**Our Case Number:** ABP-319023-24

**Re:** Combined Cycle Gas Turbine and Open Cycle Gas Turbine Thermal Power Plant, Electricity Grid Connection including 2 no. substations, and associated buildings, plant, site works, service and ancillary development on land within the townlands Knockdrin, Derrygreenagh, Derryarkin, Derryiron, Ballybeg, Coolcor, Barrysbrook, Clonin, Togher and Coole, Co. Offaly. ([www.derrygreenaghpowerplanning.ie](http://www.derrygreenaghpowerplanning.ie))

Our Ref: PAR 4351

**Re: Strategic Infrastructure Development ABP – 319023-24; Proposed Combined Cycle Gas Turbine (570MW) and an Open Cycle Gas Turbine (140MW) Thermal Power Plant and electricity grid connection including 2 no substations and associated buildings, plant, site works services and ancillary development on land within the townlands of Knockdrin, Derrygreenagh, Derryarkin, Derryiron, Ballybeg, Coolcor, Barrysbrook, Clonin, Togher and Coole, Co. Offaly.**

TITLE: **PROPANE STORE
PLAN ELEVATIONS & SECTION**

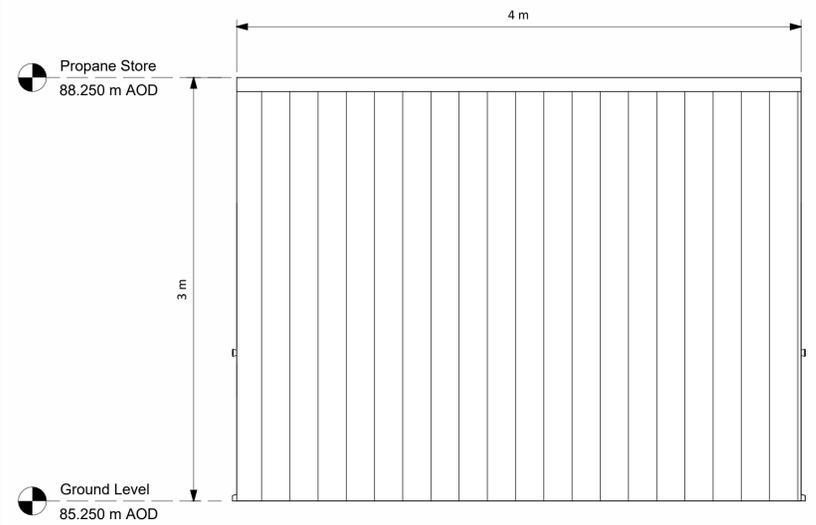
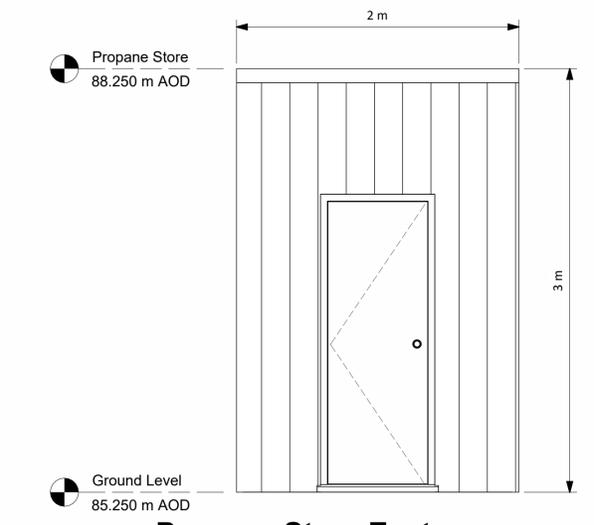
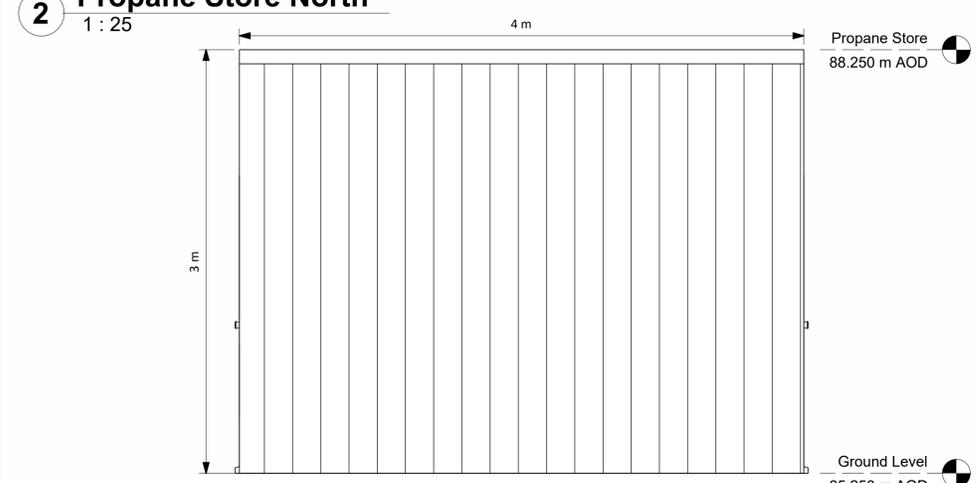
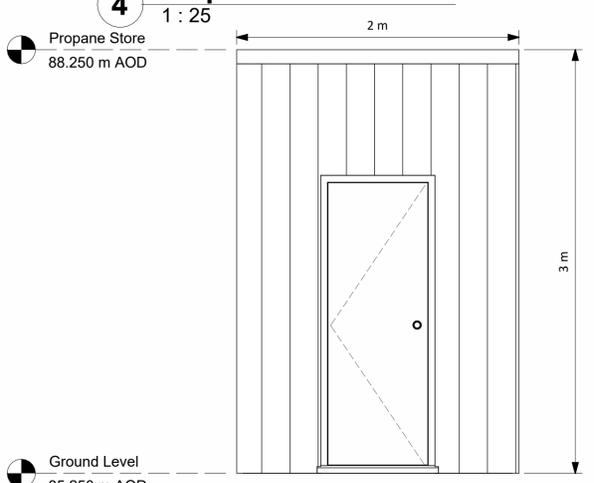
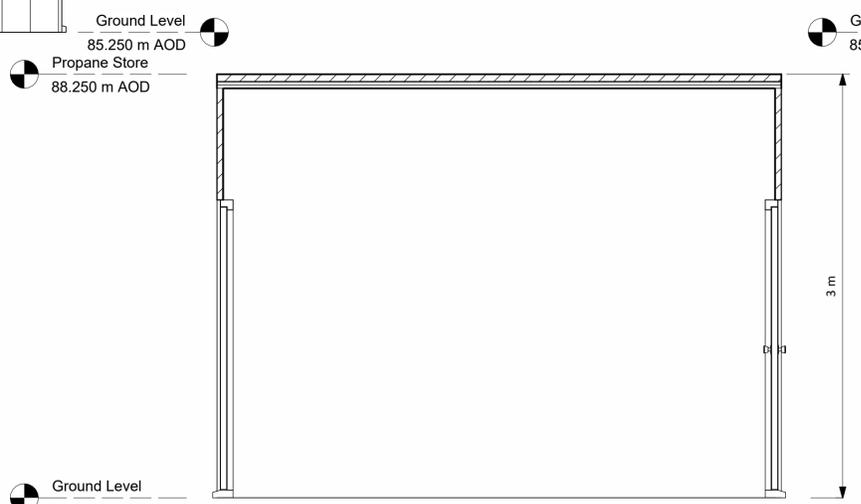
15. Section 3.1 of TLUP lists the LPG scenarios that are to be modelled. No description of LPG is included particularly pipelines, the report refers to 'propane cylinders', yet there is no discussion or assessment of storage/filling as applicable. Refer to TLUP table 23, domino LPG BLEVE during loading operation TLUP table 26 and TLUP section 3.10 gas cylinders.

DRAWING No.: **S7060-8050-0055-1** Sheet 1 of 8 REVISION: **R1.0**

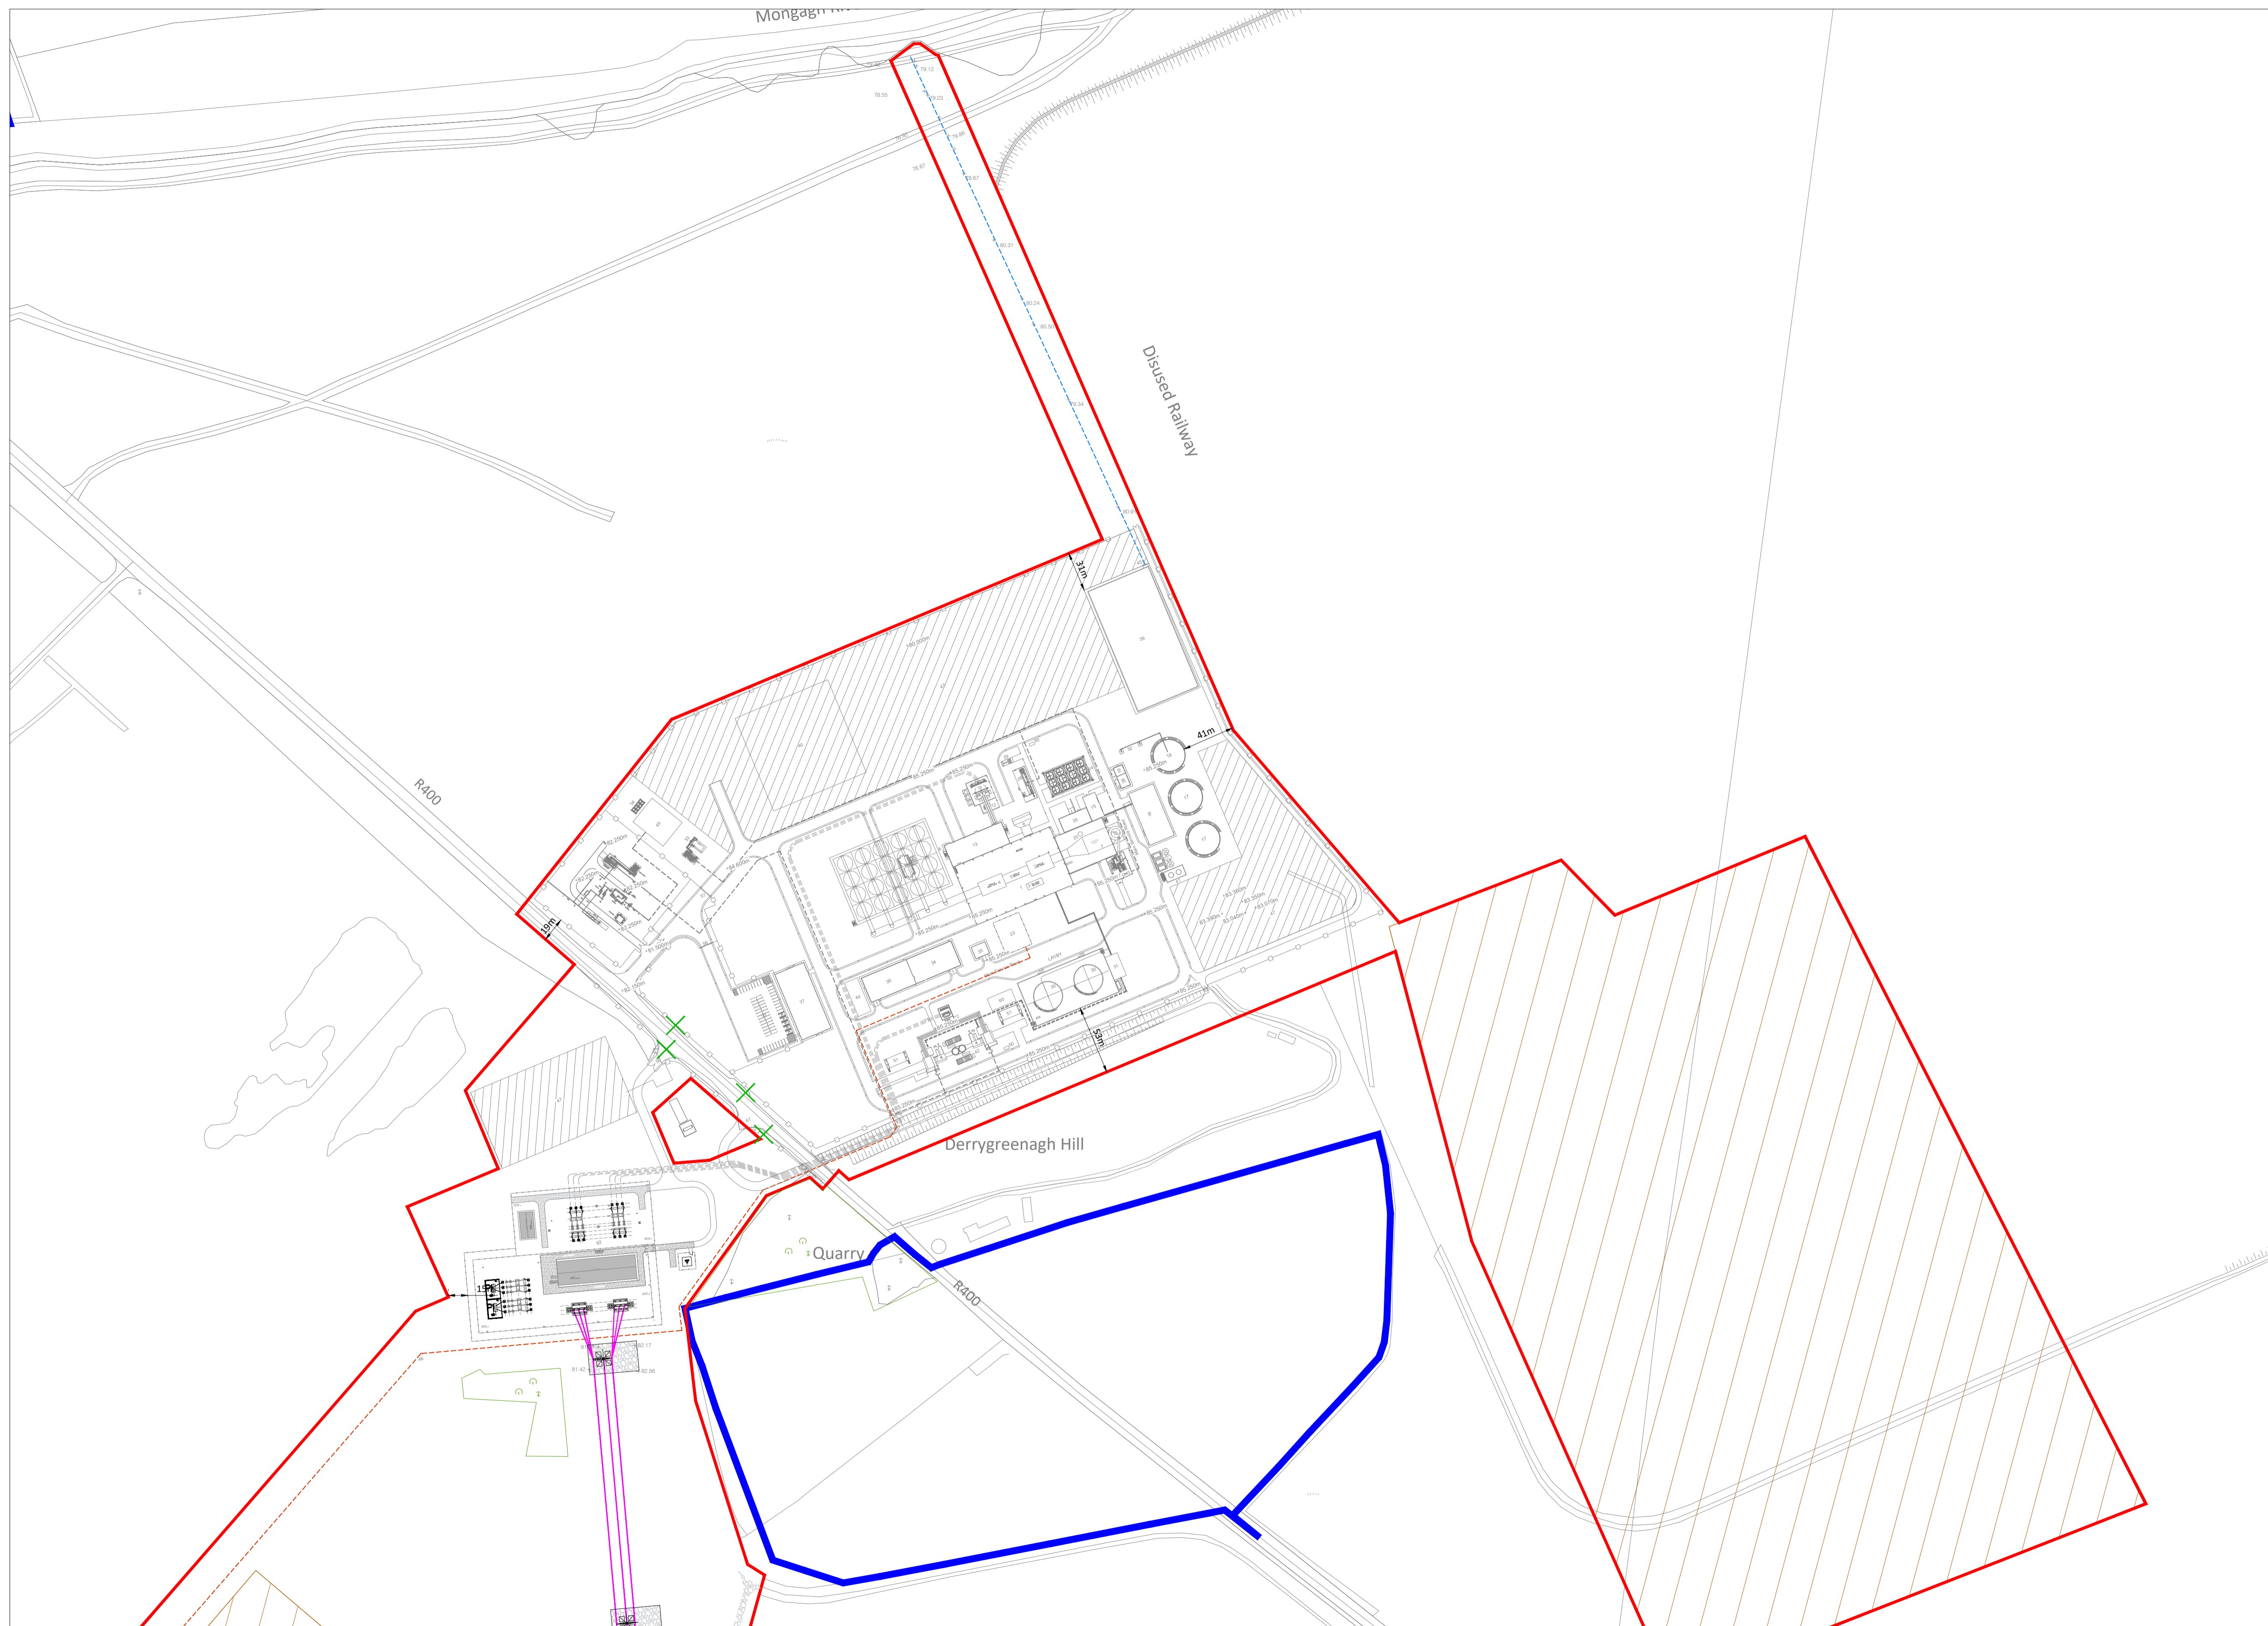
4. The site boundary indicated in Appendix 16.3 of EIA is different to that on the proposed development overview plan sheet 1 of 8. Buildings to the south of site, beside quarry – have not been identified or described.
